**From:** Brenda Larsen  
**Sent:** Thursday, April 10, 2014 10:00 AM  
**To:** Kaycee Hathaway  
**Subject:** RE: Kittitas County Notice to Agencies BL-14-00006 Trinity Farms

Re: Trinity Farms (BL-14-00006)

After conducting a review of the above named project, I have the following comments:

Forman / Shelton BLA

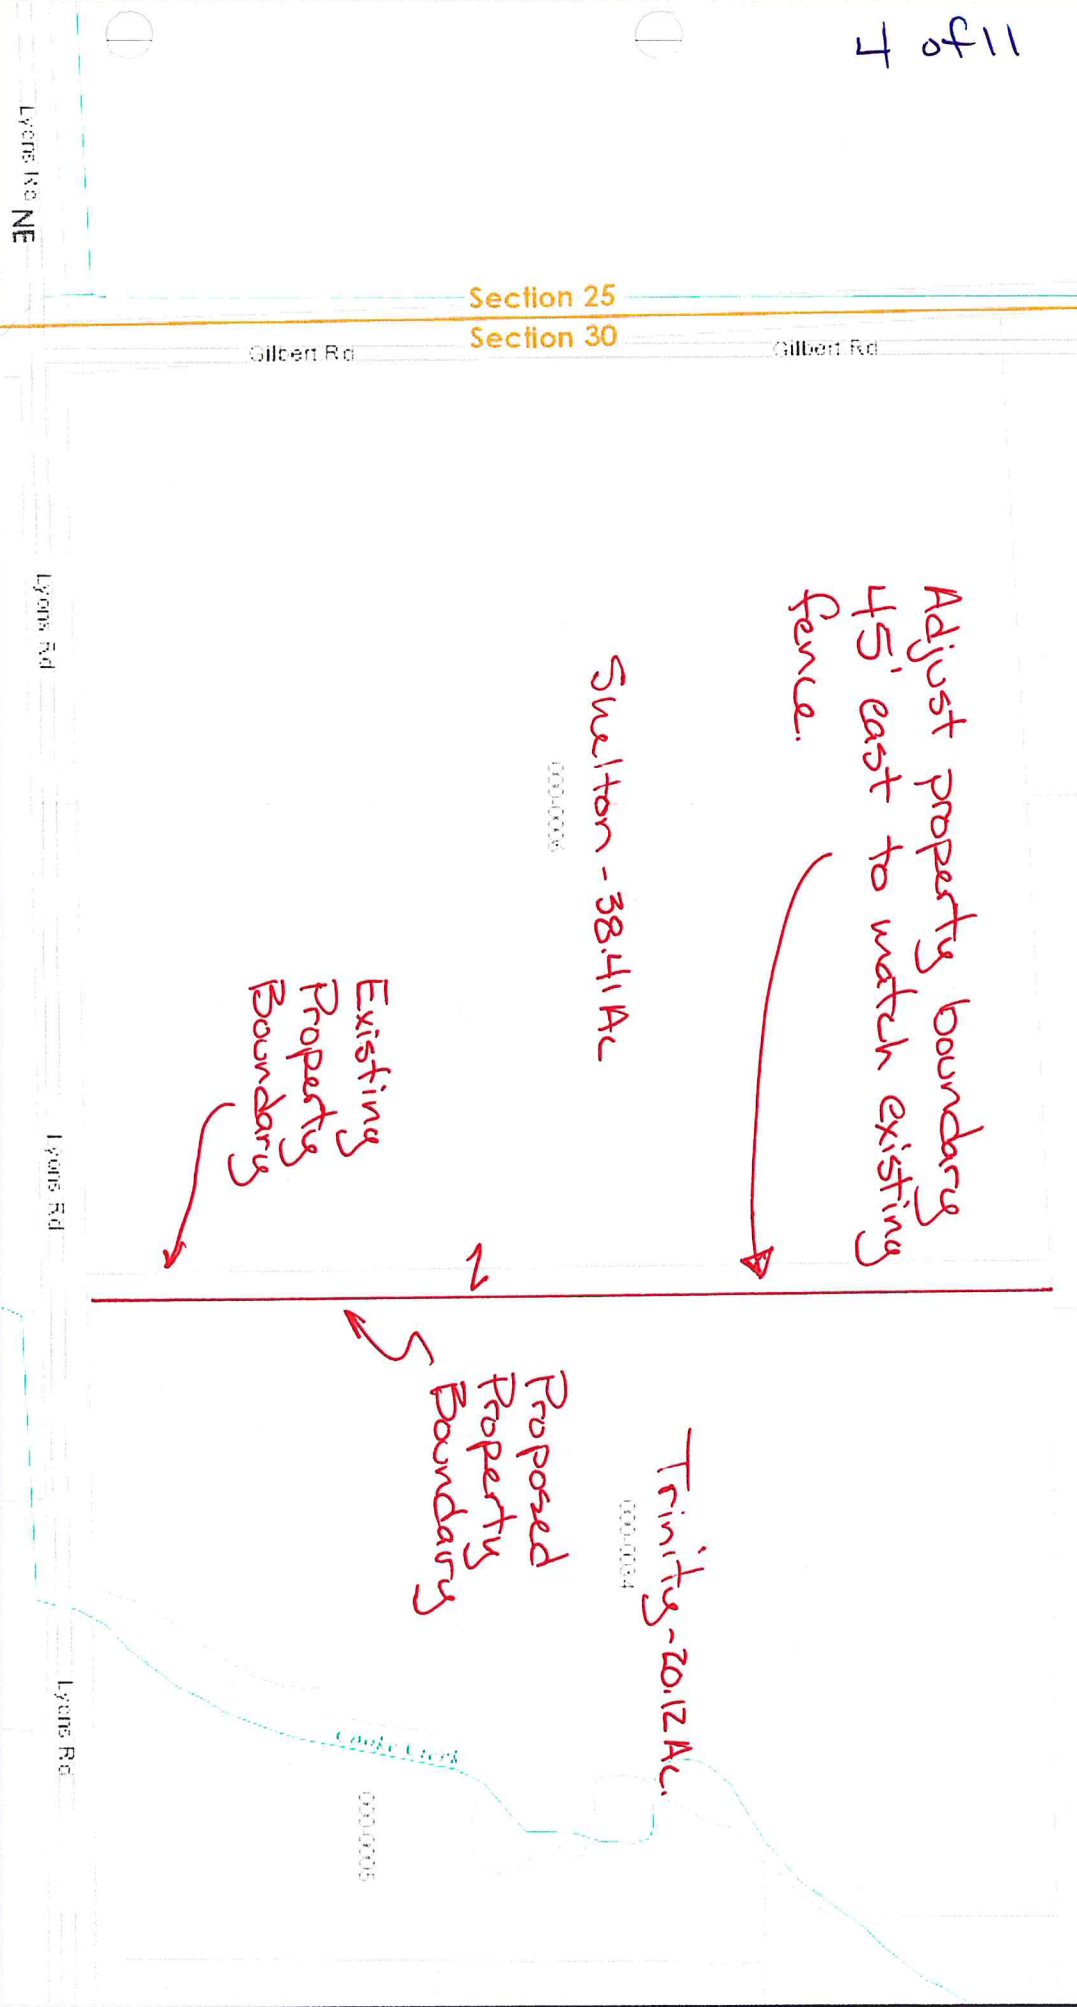
- Ensure that boundary line adjustments do not infringe upon existing structures, to include propane tanks, etc.
- Ensure adequate access for fire apparatus. Any driveways or access points created based off the new lot configurations shall comply with Kittitas County Code 20.02.030.
- All future development must comply with the International Fire Code.
